# Rezoning Transportation Analysis

Petition Number: 2023-012

**From:** Jake Carpenter, PE  
Jacob.carpenter@charlottenc.gov  
980-221-5675

## Revision Log:

REZONING
SITE PLAN

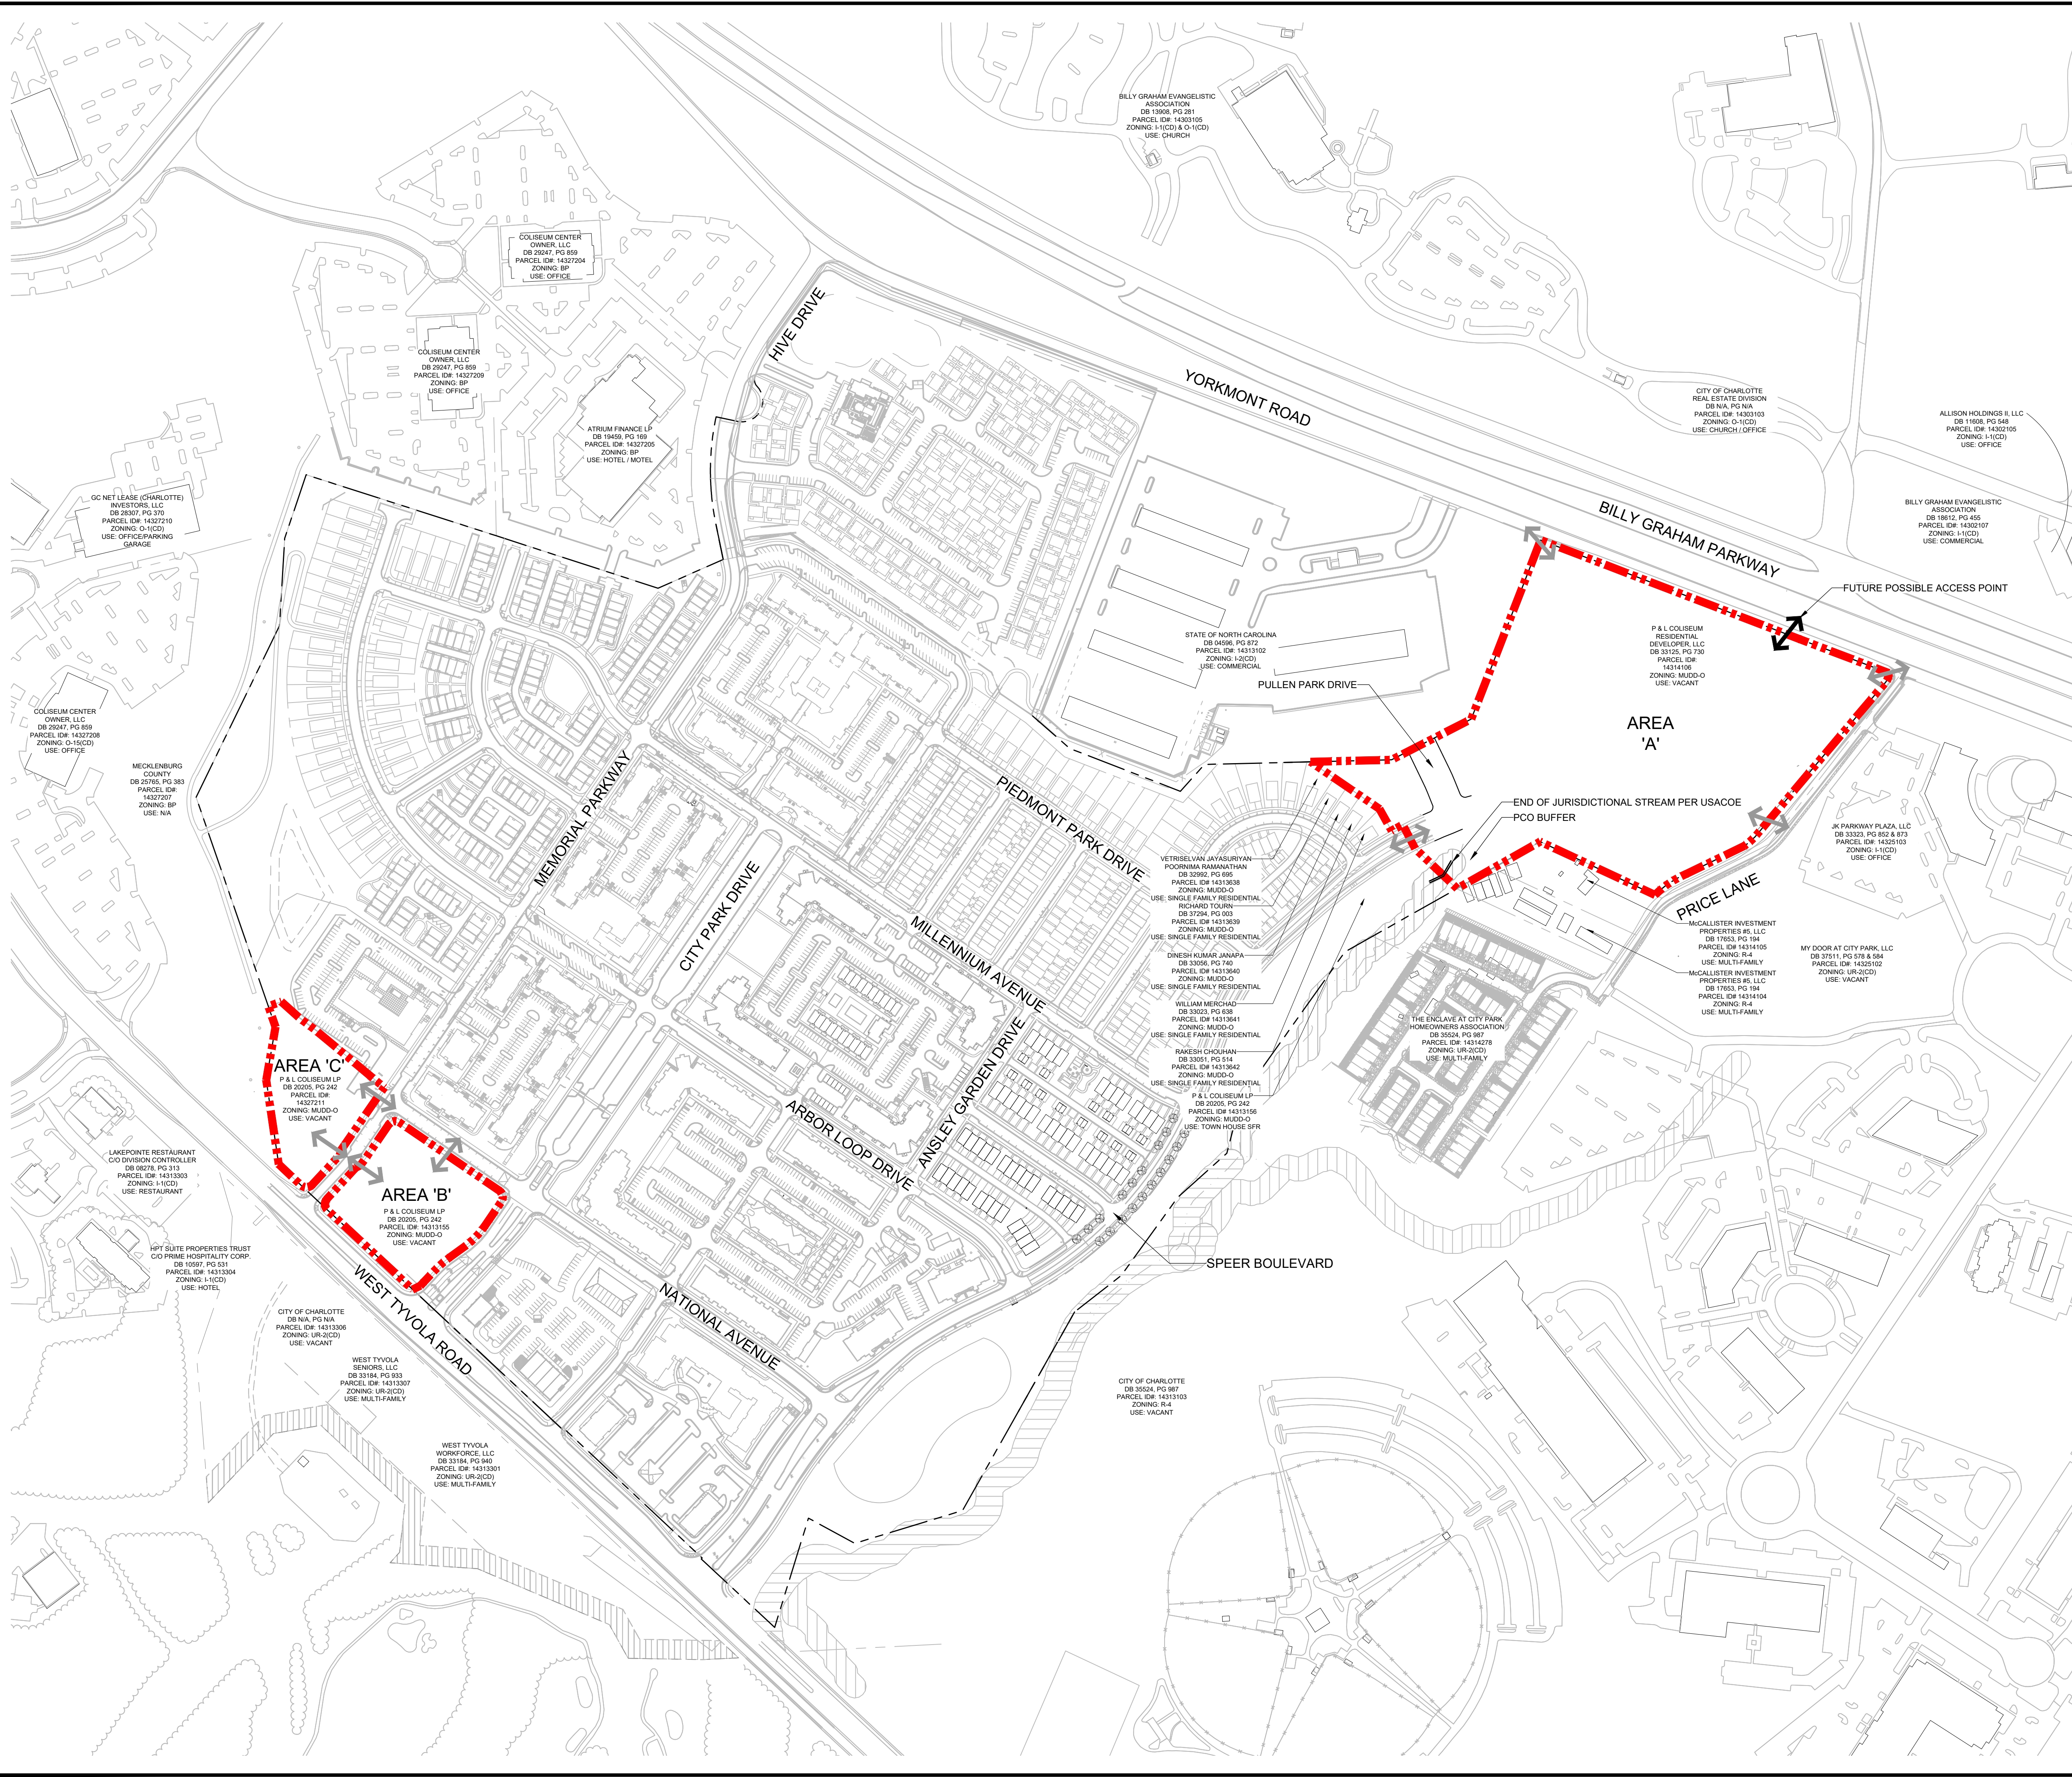
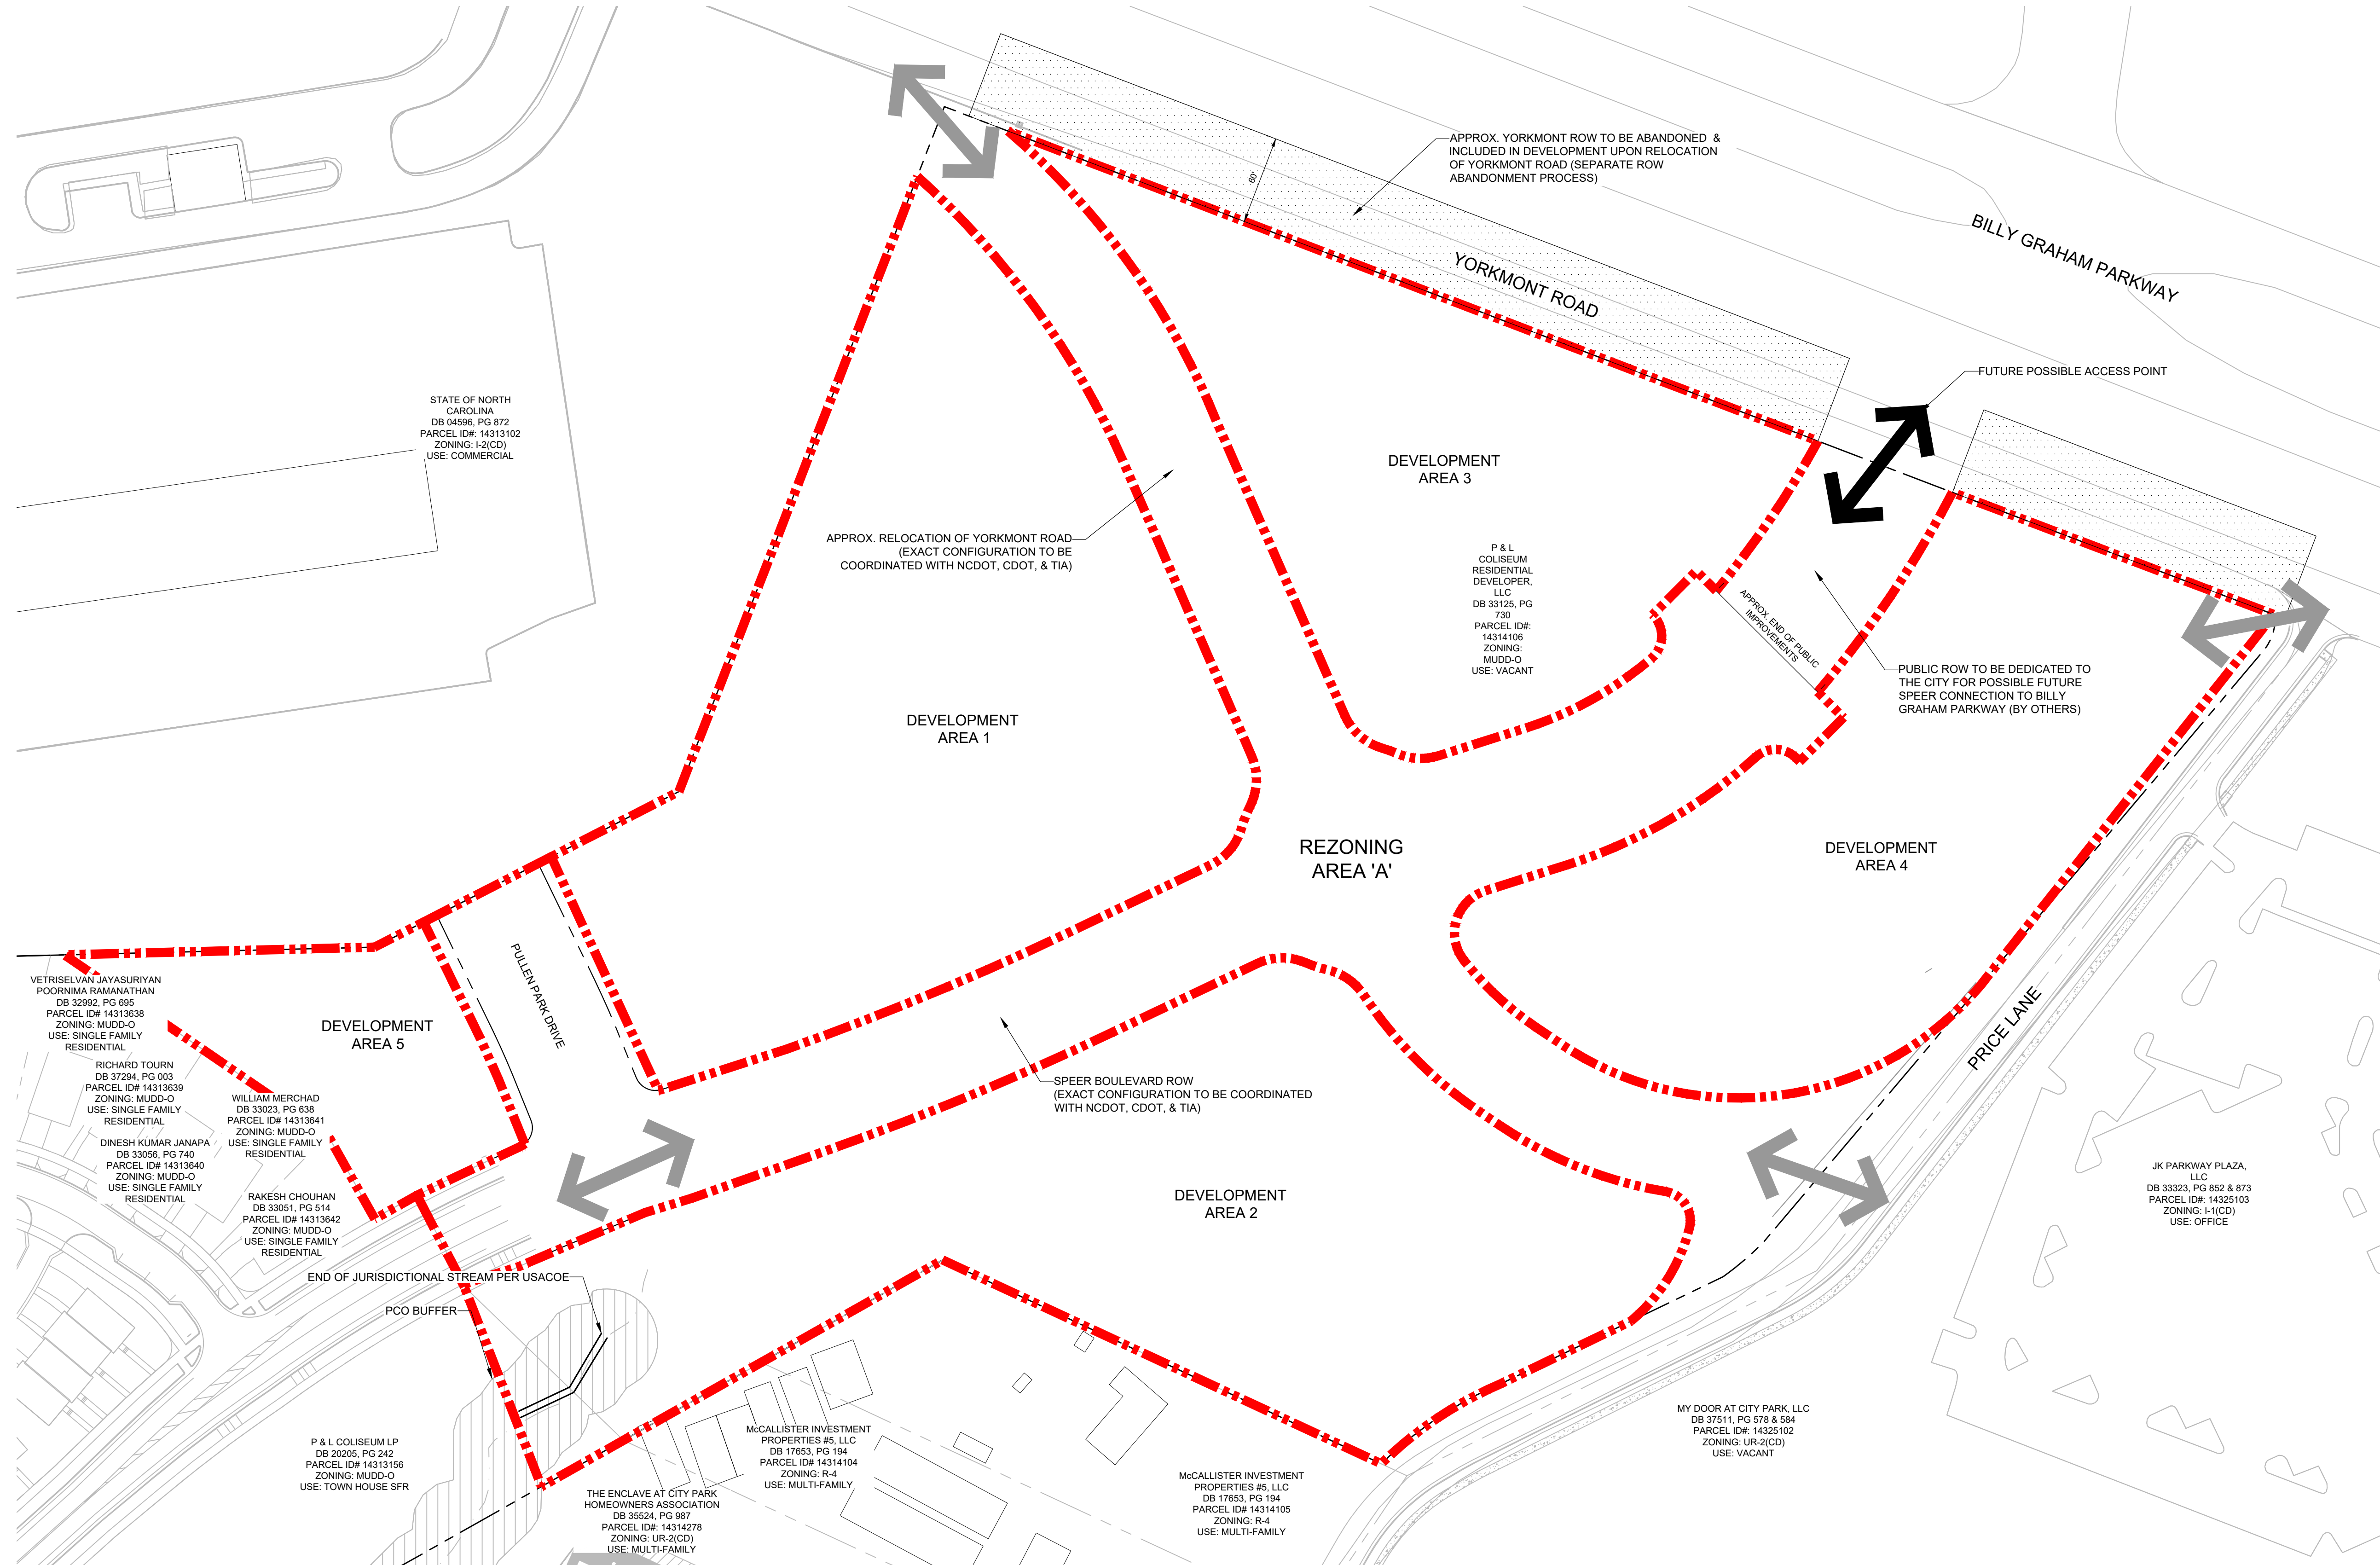
~~Label and dimension the curb and gutter from the centerline for each road on the site plan.~~

**Outstanding Comment from 6.21.23:** Label and dimension the curb and gutter from the centerline for each road on the site plan.

~~3. Revise site plan and conditional note(s) to commit to dedicate a minimum of 35 feet of right-of-way from the road centerline on Yorkmont Road and Speer Boulevard. The site plan shall label and dimension the right-of-way from the road centerline.~~

~~**Clarifying comment 6.21.2023:** Add conditional note to dedicate a minimum 35 feet of ROW from the roadway centerline of Yorkmont Road and Speer Boulevard. Additionally label and dimension.~~

~~4. Revise site plan and conditional note(s) to commit to provide an 8-foot planting strip, and 8-foot sidewalk along Yorkmont Road and Speer Boulevard per the Charlotte Streets Map.~~

**Clarifying comment 6.21.2023:** Add conditional note to provide 8 foot planting strip and 8 foot sidewalk along Yorkmont Road and Speer Boulevard. Additionally, revise to show 8 foot sidewalk.

5. ~~Revise site plan and conditional note(s) to commit to construct bicycle facilities by locating the curb and gutter 18.5' on Speer Boulevard and 24' on Yorkmont Road from the center line/installing a bike lane to meet the Council adopted Charlotte BIKES Policy.~~

**Clarifying comment 6.21.2023:** Add conditional note to construct bicycle facilities on Speer Boulevard and Yorkmont Road.

**Clarifying comment 6.21.2023:** Add conditional note about ROW dedication to the City for possible future Speer connection to Billy Graham Parkway. Speer Road Stub needs to be extended to property line if it will not tie into Billy Graham Parkway.
